COUNTY COUNCIL'S RESPONSE TO CONSULTATION ON THE FOLLOWING DEVELOPMENT PROPOSAL

Application no: 19/00446/F

Proposal: Erection of up to 57 residential units (Use Class C3) comprising a mix of open market and affordable housing, together with associated works including provision of vehicular and pedestrian accesses, public open space, landscaping, infrastructure and site clearance.

Location: Heyford Park Camp Road Upper Heyford Bicester

VEHICLE TRACKING LAYOUT

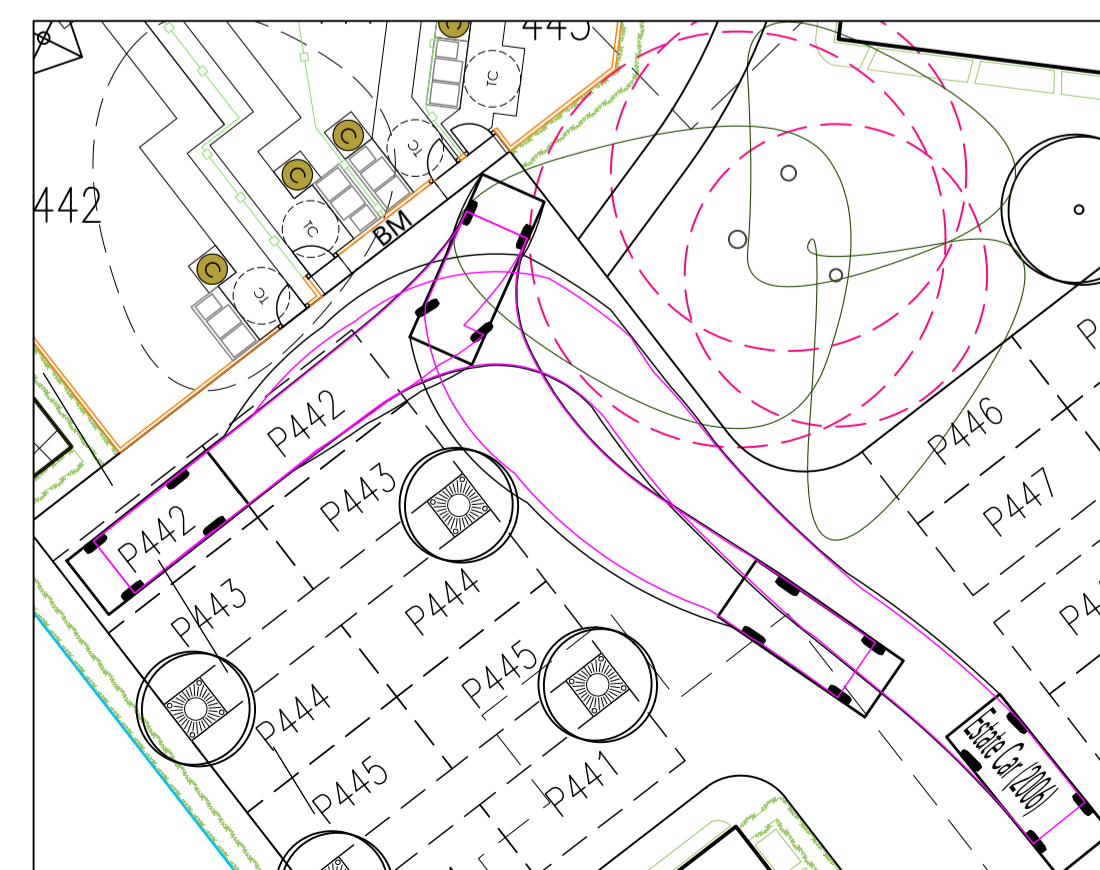
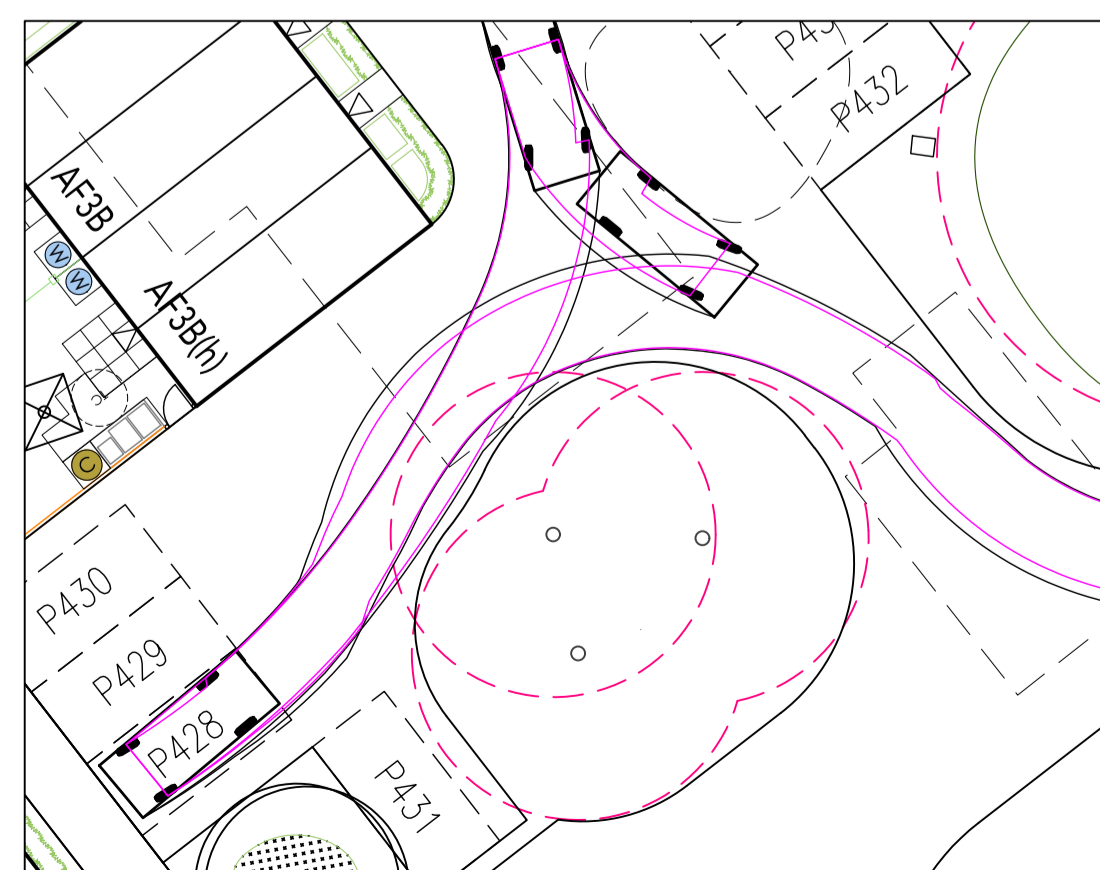
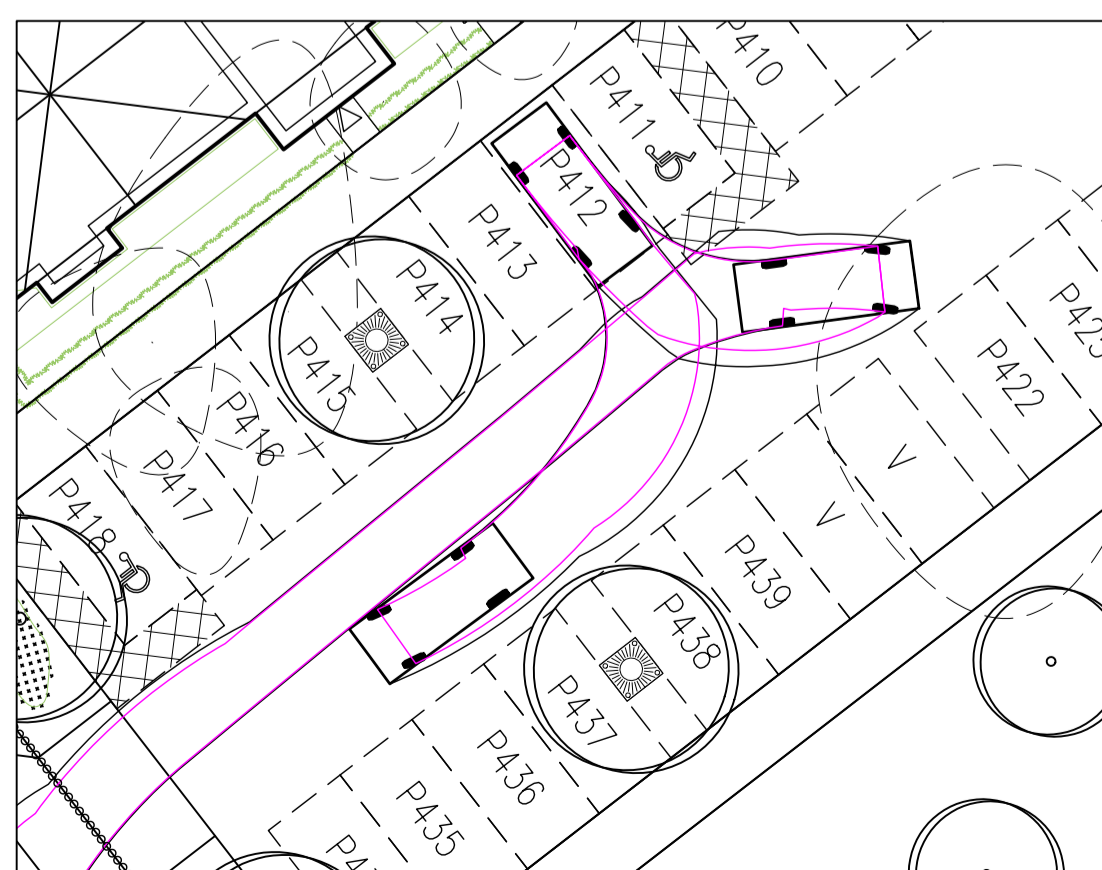
Trenchard refuse vehicle tracking does not demonstrate how a refuse vehicle outside plot 31 will exit the site. It is not clear whether the vehicle will exit via the eastern section of Trenchard Circle which is not within the application boundary, or whether it will turn and exit via the western section of Trenchard Circle. The exit strategy needs to be demonstrated. **Reason for objection.**

DRAWING TITLE: VEHICLE TRACKING LAYOUT
 DRAWING NO: 0521-PH8A-8C-105

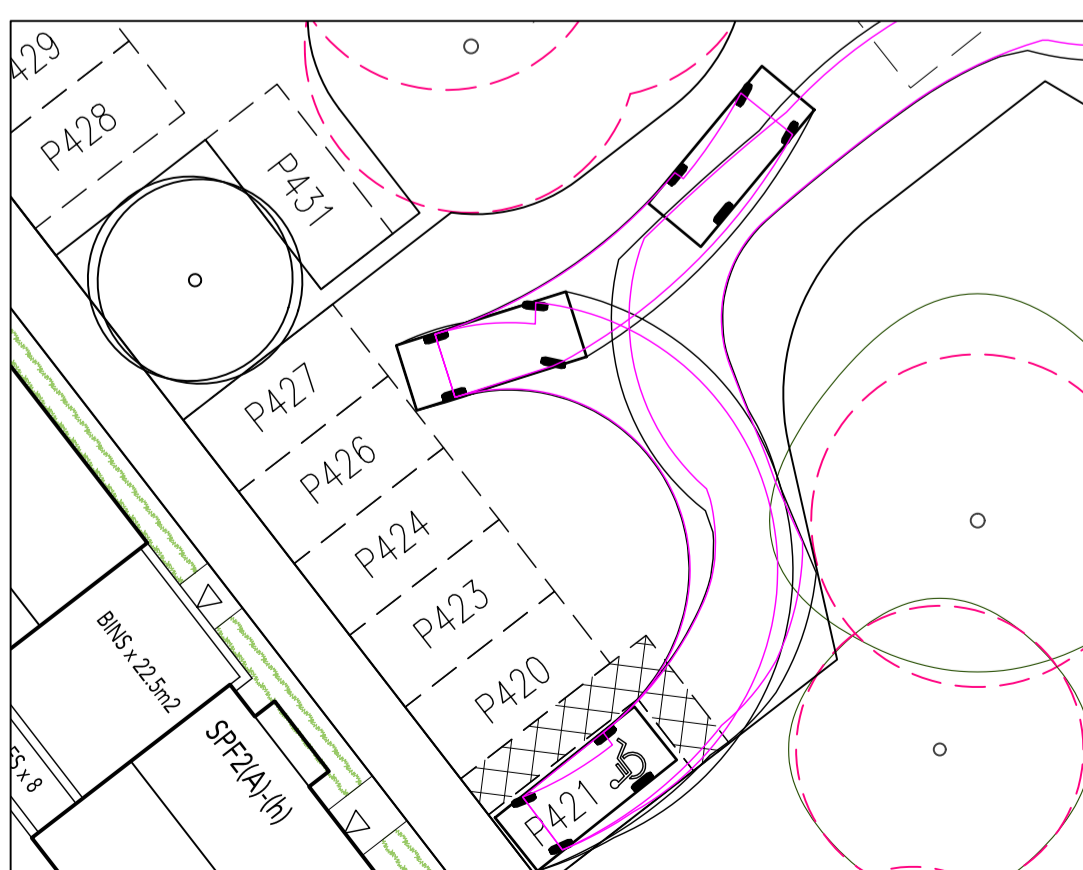
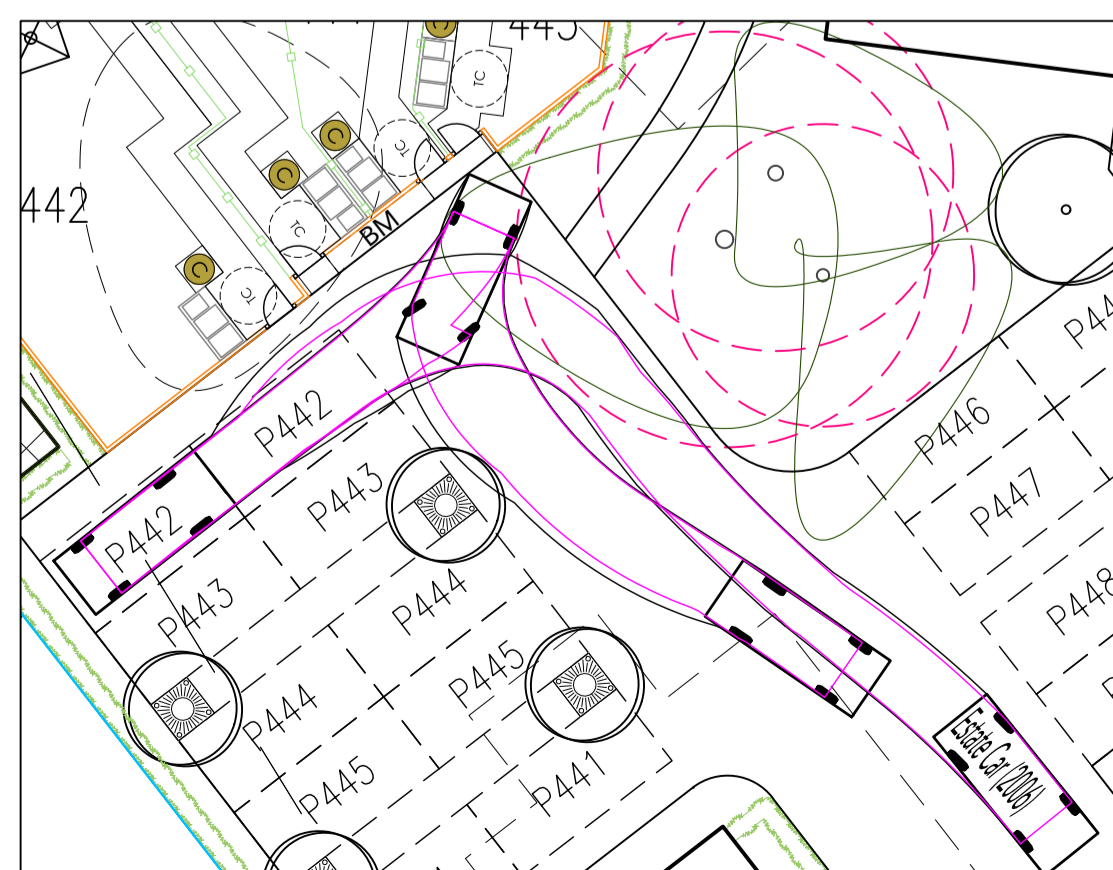
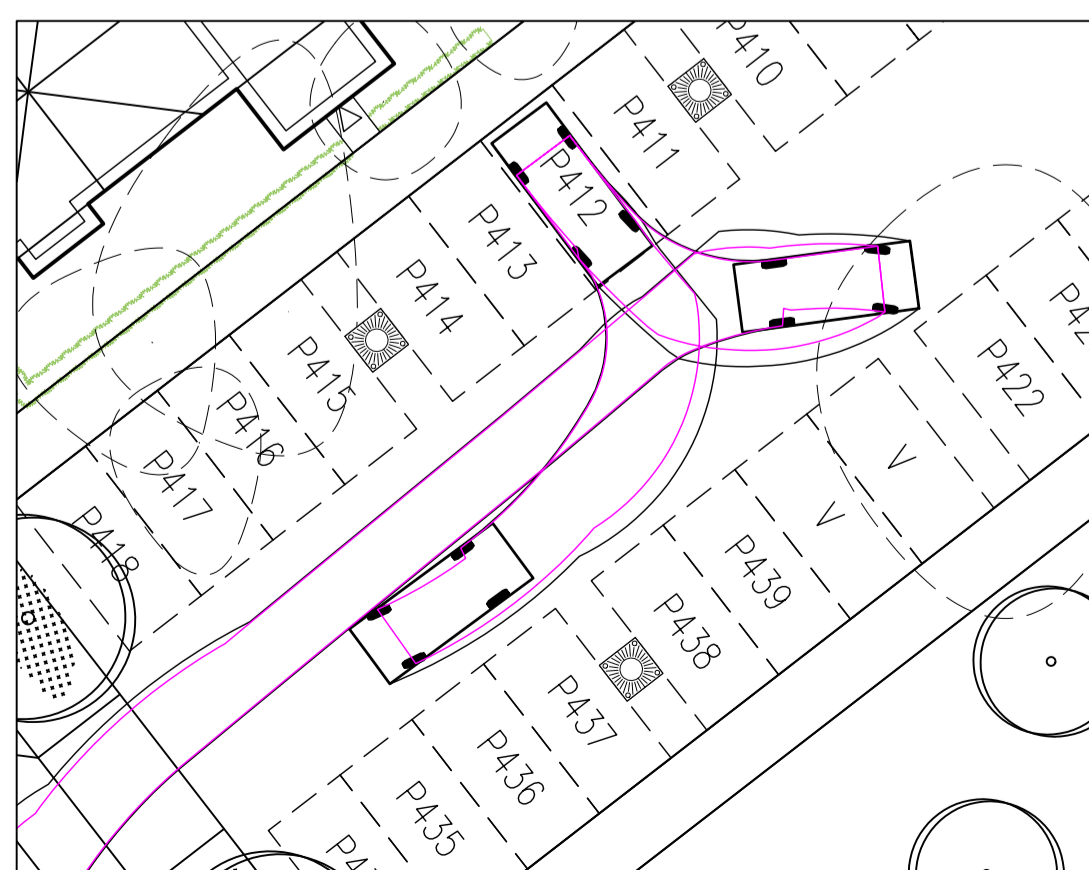
Phase 8C car park layout to the south of plots 410-427 is inadequate as there is no turning area for vehicles should the carpark be full. Vehicle tracking into and out of parking spaces is acceptable. However, it is not possible to see if the car park is full without entering it and if it is found to be full, there is no area for the vehicle to then turn and exit the car park in forward gear. **Reason for objection.**
